Ref: D23/70047

16<sup>th</sup> October 2023

**RE: Oven Mountain Pumped Hydro Energy Storage Project EIS SSI-12422997 Exhibition –  
Kempsey Shire Council**

Figure 1.27 Number of workers throughout the construction period

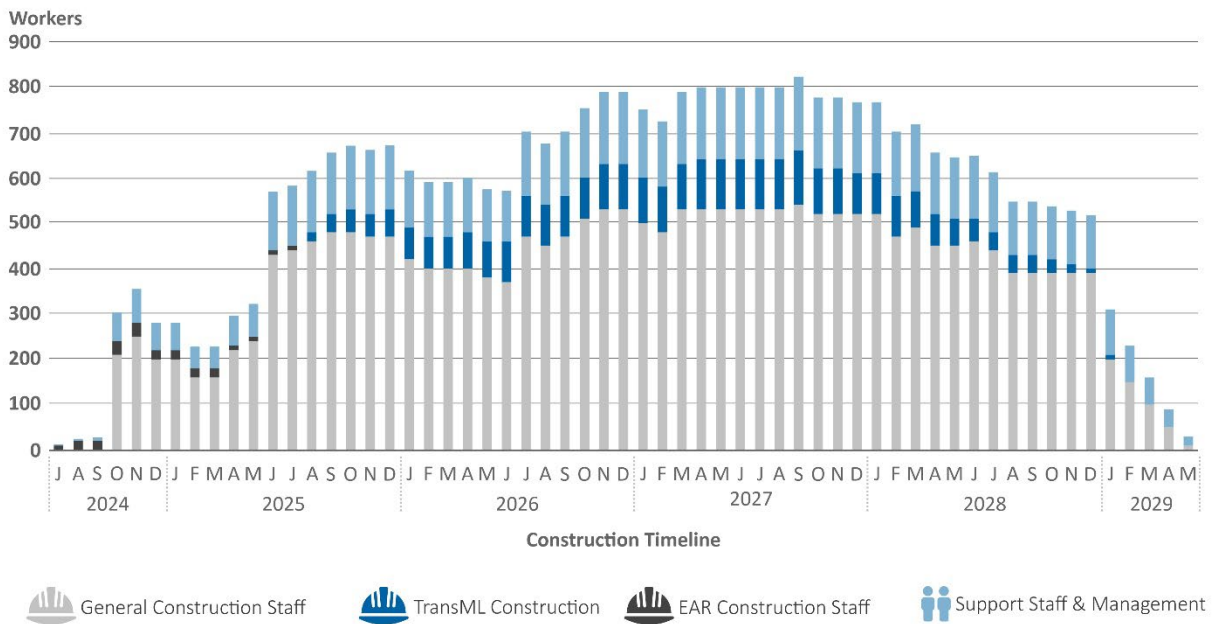
Figure 4.3 of Appendix W: Social impact assessment identifies that for at least 12 months worker numbers during construction will be well above 500 at around 700. For comparison Bellbrook has a current population of 339 people. The EIS considers the accommodation camp is the solution to the proportionately large influx of workers to a remote location. Successive state significant projects in rural and regional localities show that many workers want to live with partners or family locally and with their higher earnings – the impacts on availability of affordable housing/rentals market and implications for local businesses are negative and significant for the community. The EIS does not consider this eventuality.
